**APPLICATION FOR:** 35085/APP/2022/2548  
65 BERWICK AVENUE HAYES

**Item No.** Report of the Interim Director of Planning, Regeneration & Public Realm

**Development:** Change of use from a maximum 6-person HMO (use class C4) to a 6-bed, 10-person HMO (sui generis)

Scale of Drawing
 1/100 @ A1
Drawing No
 65 001
Drawn By
 Sunny Bahia
Date of Proj
 Aug 20

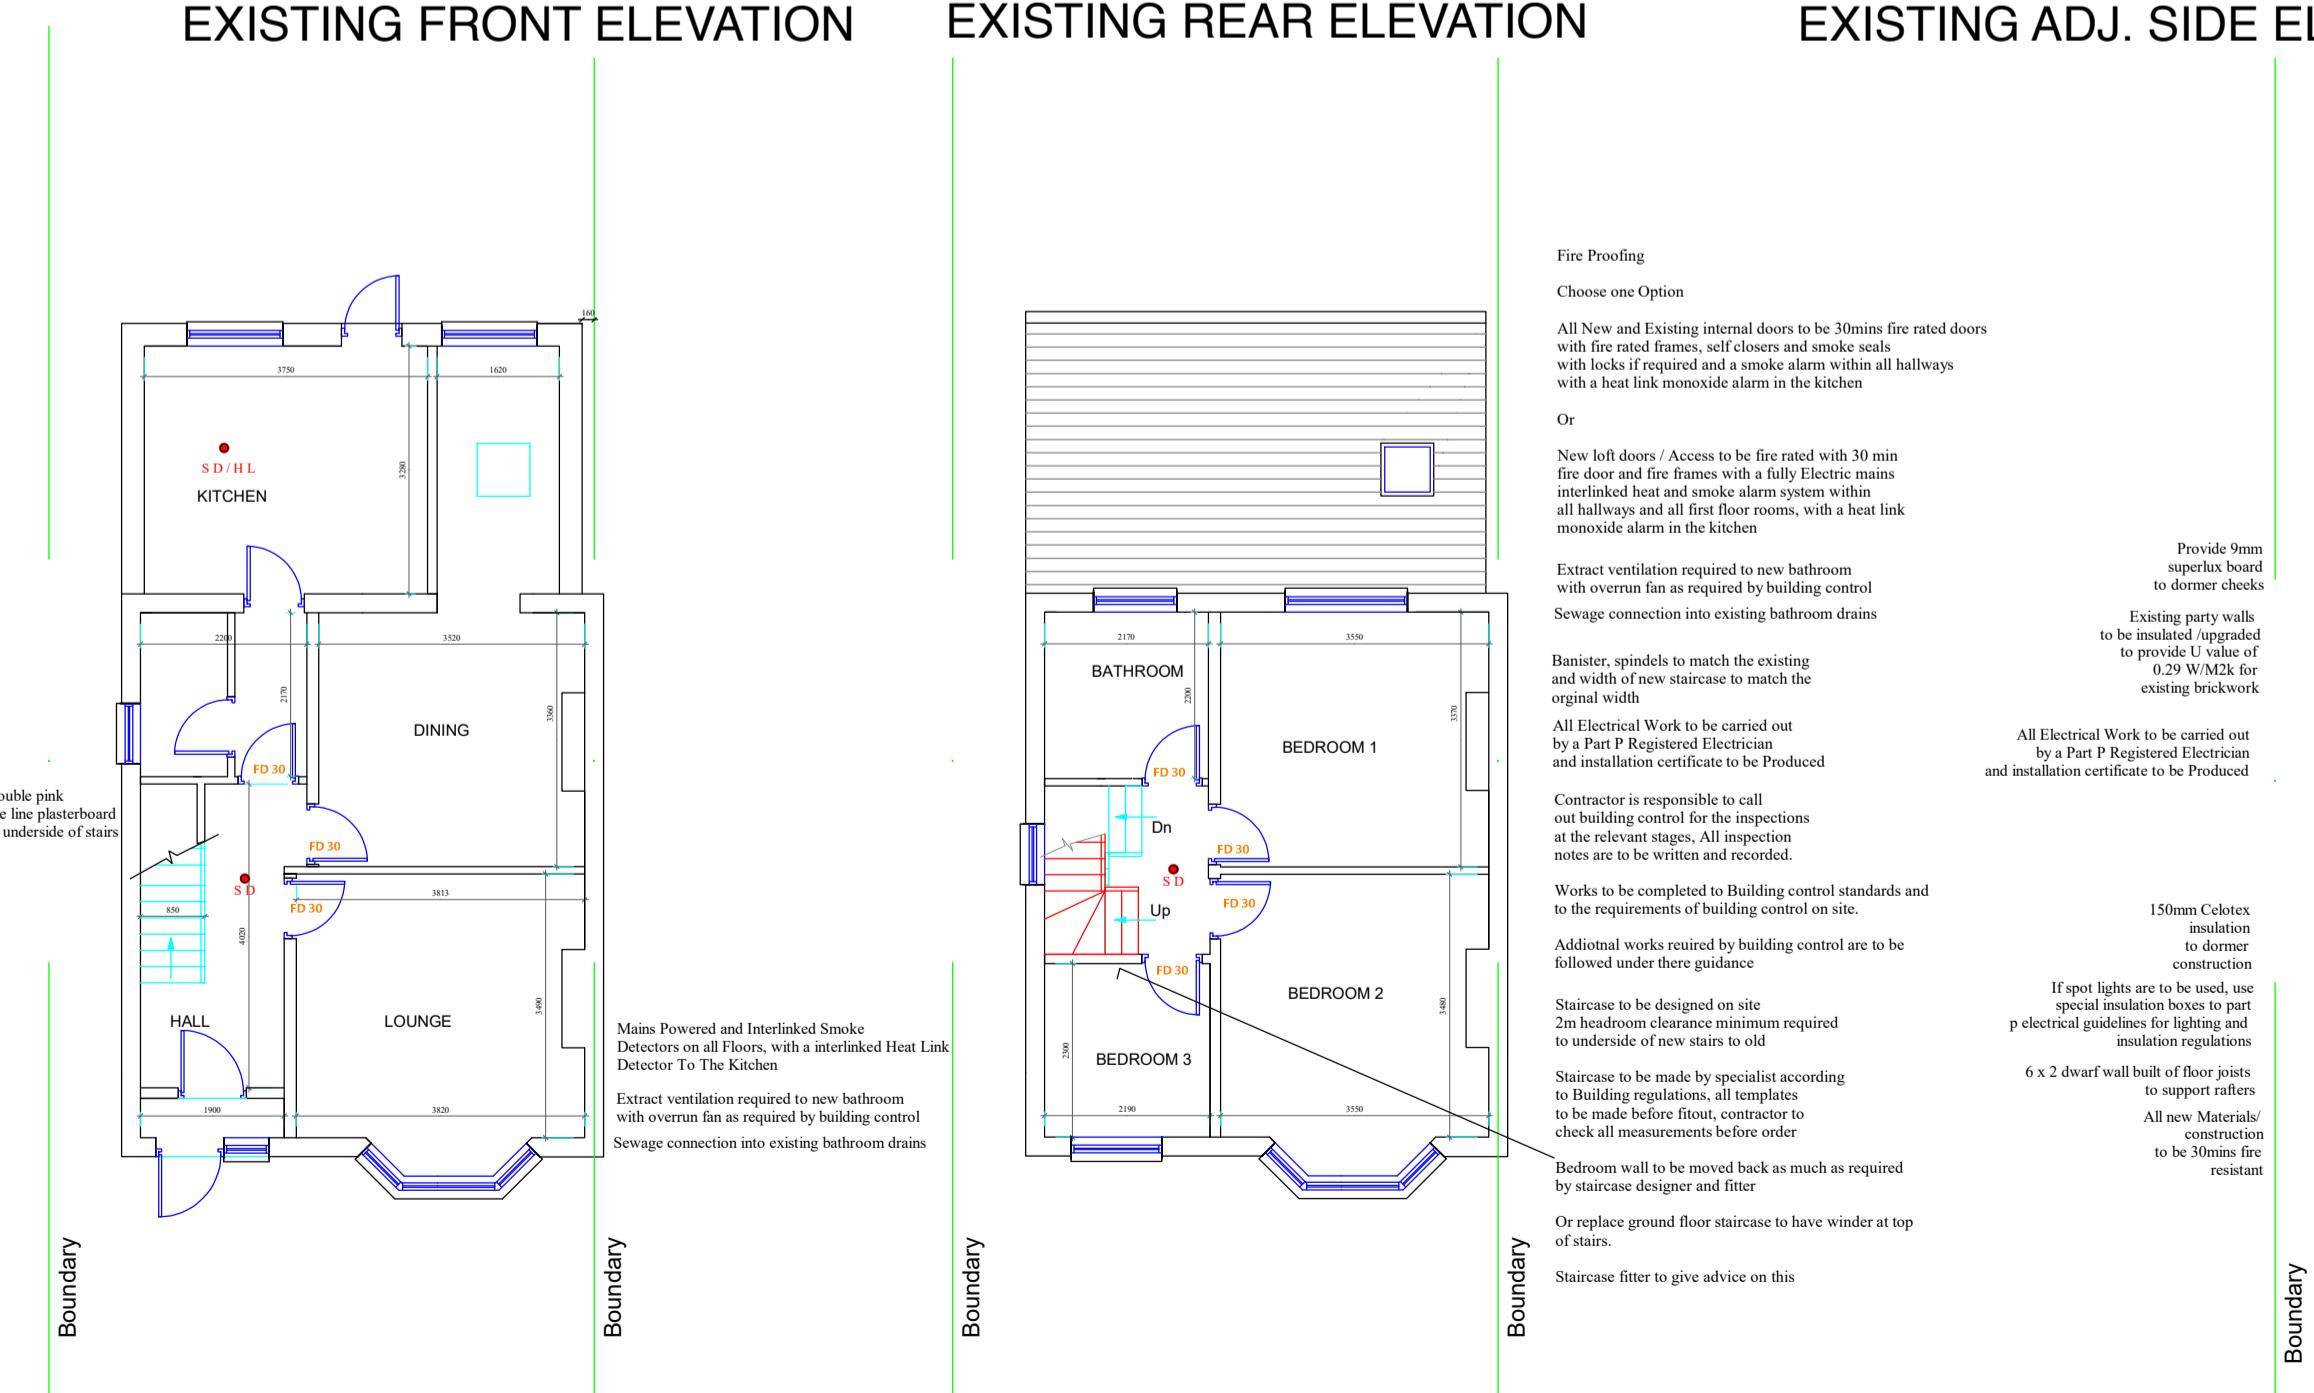
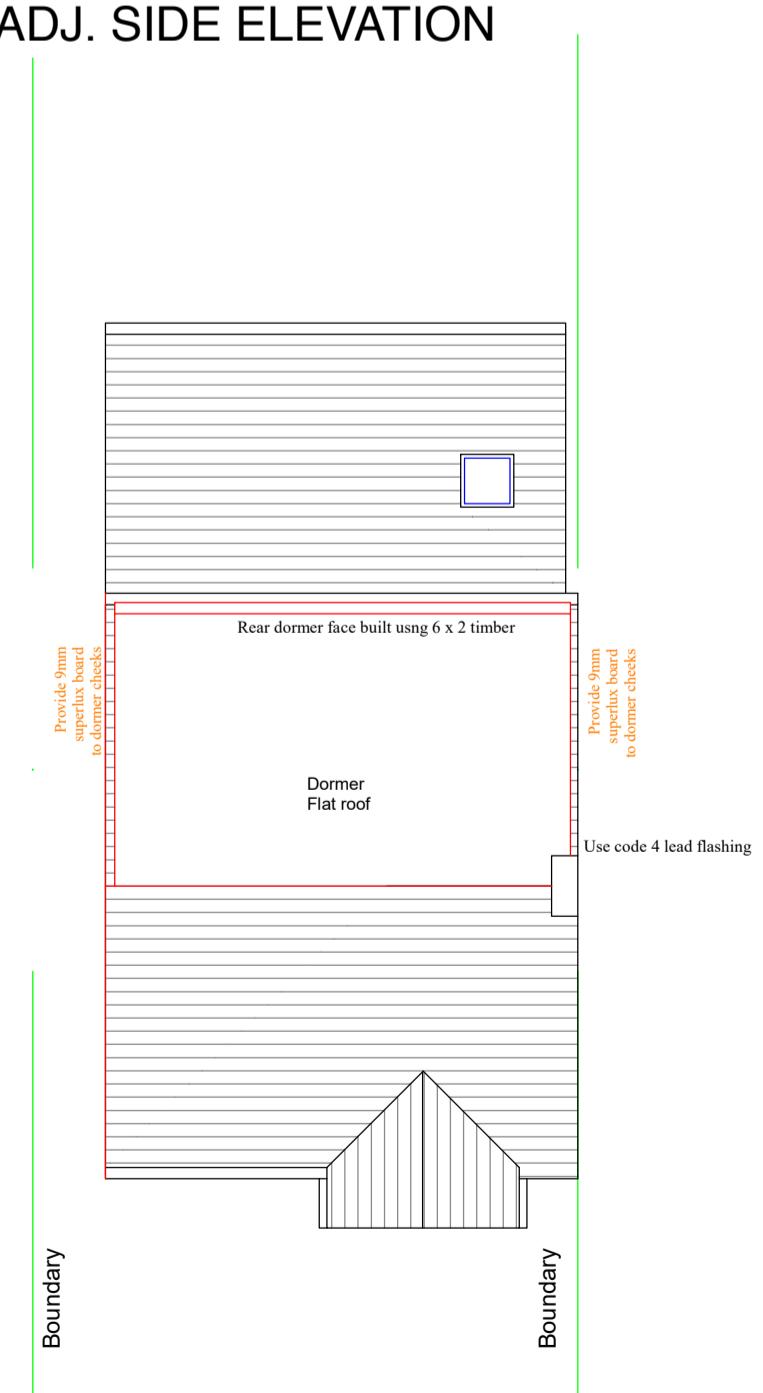
Bedroom sizes are required to be at least 7.5sqm and 2.15m wide for single occupancy rooms (or 11.5sqm and 2.55m wide for double occupancy rooms). The proposed bedrooms vary between 5sqm and 23sqm. There are a total of five double bedrooms, but Room 5 is noted to be of insufficient size as a single occupancy room (albeit this is an existing bedroom).

The kitchen has an internal floorspace of 12sqm (excluding cupboard and bench space), which appears inadequate for ten occupants. There is also no identified storage.

There are two ground floor bedrooms proposed - one adjacent to the front door (Room 1) and one at the rear alongside the kitchen (Room 2). There is likely to be some noise transfer between the parking area and the bedroom at the front of the property (Room 1), although this would not be an entirely uncommon arrangement. However, there are more significant concerns in respect of Room 2, in relation to noise transfer from the kitchen. Whilst it is feasible that some treatment to the wall could be implemented to minimise noise transfer, it is unlikely to sufficiently eliminate noise from the use of the kitchen by up to nine residents at any one time, giving rise to concerns about whether a

suitable acoustic environment could be provided for the occupant(s) of Room 2.
